CITY OF ALBUQUERQUE

February 12, 2019

RE: 7410 Washington St. NE
Grading and Drainage Plan
Engineer's Stamp Date: 01/11/19
Hydrology File: D17D003AA

SHEET
2 OF 3

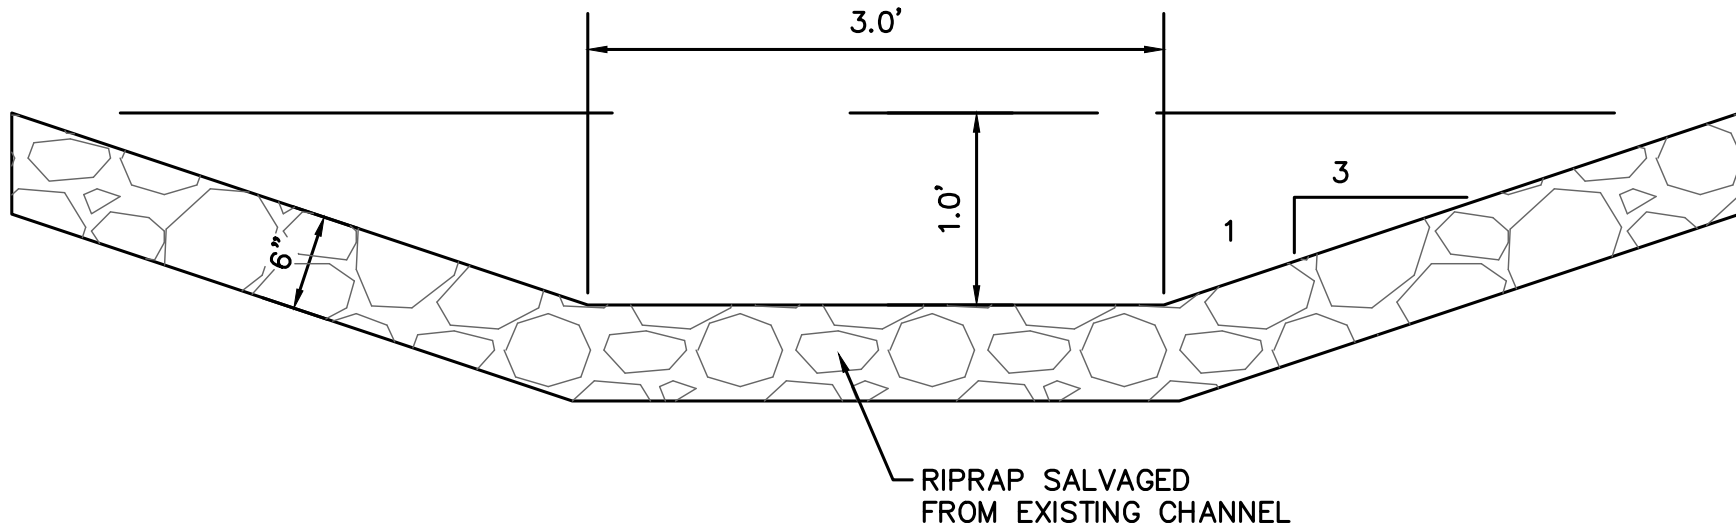
1. Please provide the benchmark information for the survey contour information provided.
2. Under Water Quality Ponding on Sheet 2, please add a note which states, "The Owner has elected to pay the Payment in Lieu for the required Stormwater Quality Volume of 463 CF. This payment Amount = 463 CF x \$8/CF = \$3,704.00."

SECTION B-B SHEET 1/3

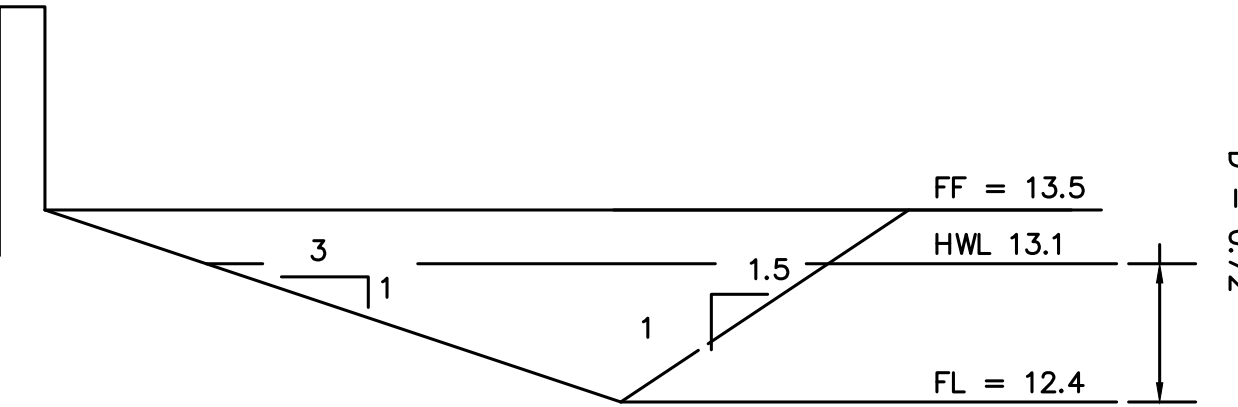
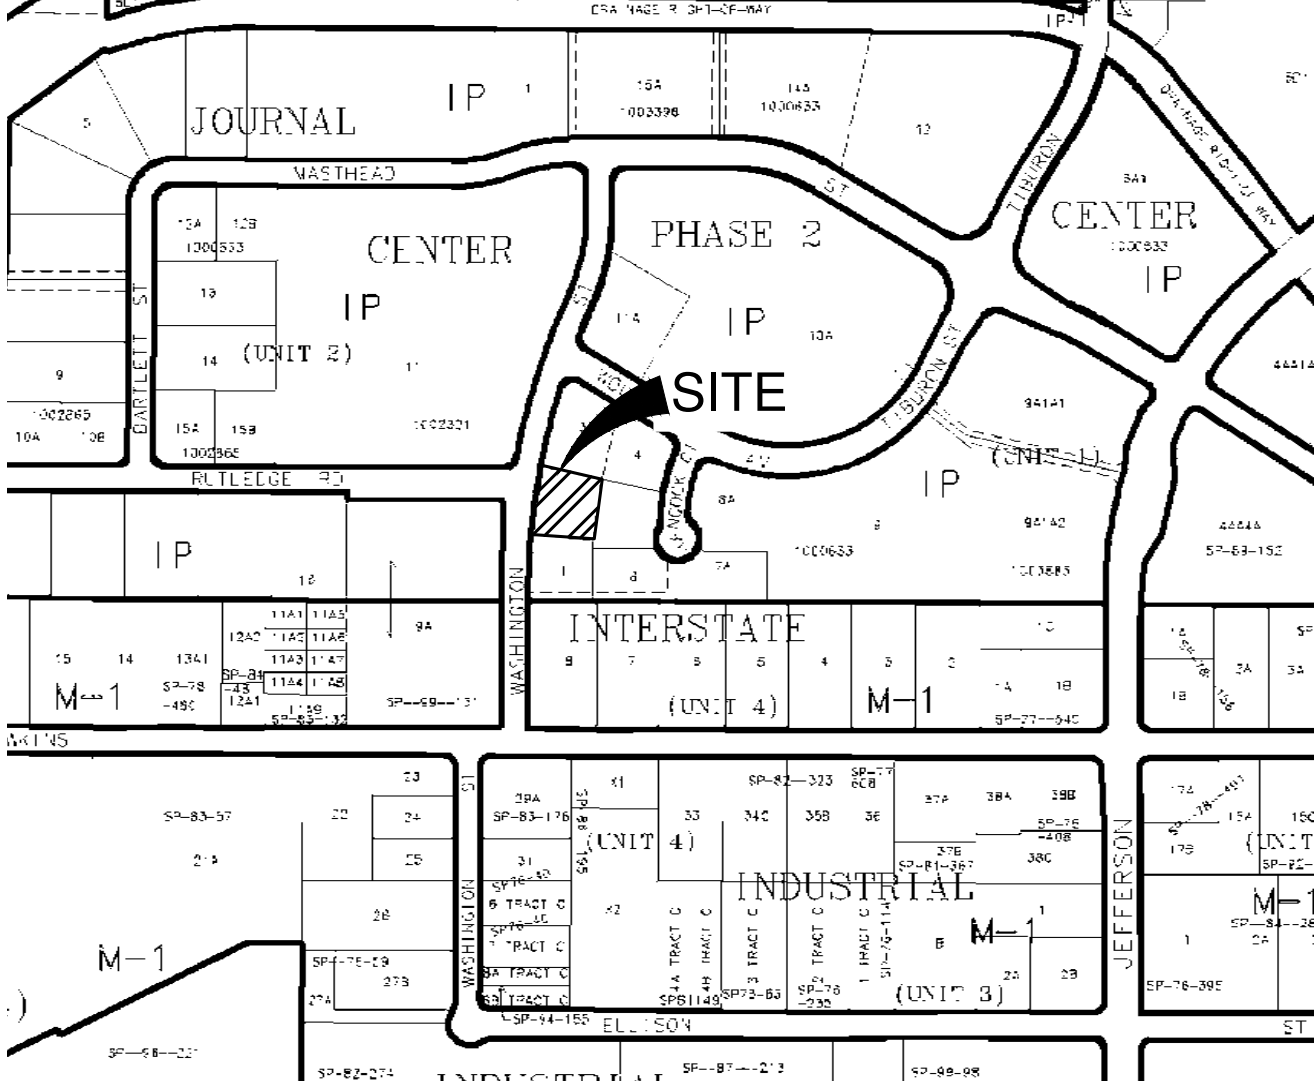
4. Please provide a cross section of the riprap channel.
5. Please provide the calculations of the proposed riprap channel. This just needs to provide for the off-site flows of 1.88 cfs.

7. Please provide a section of the proposed swale.

8. Please provide calculations for the proposed swale. This needs to provide for the off-site flows of 0.75 cfs and on-site flows of 1.09 for a combined flow of 1.84 cfs.
9. Please add the SO-19 Notes on Sheet 1. See attached.
10. Standard review fee of \$150 will be required at the time of resubmittal.
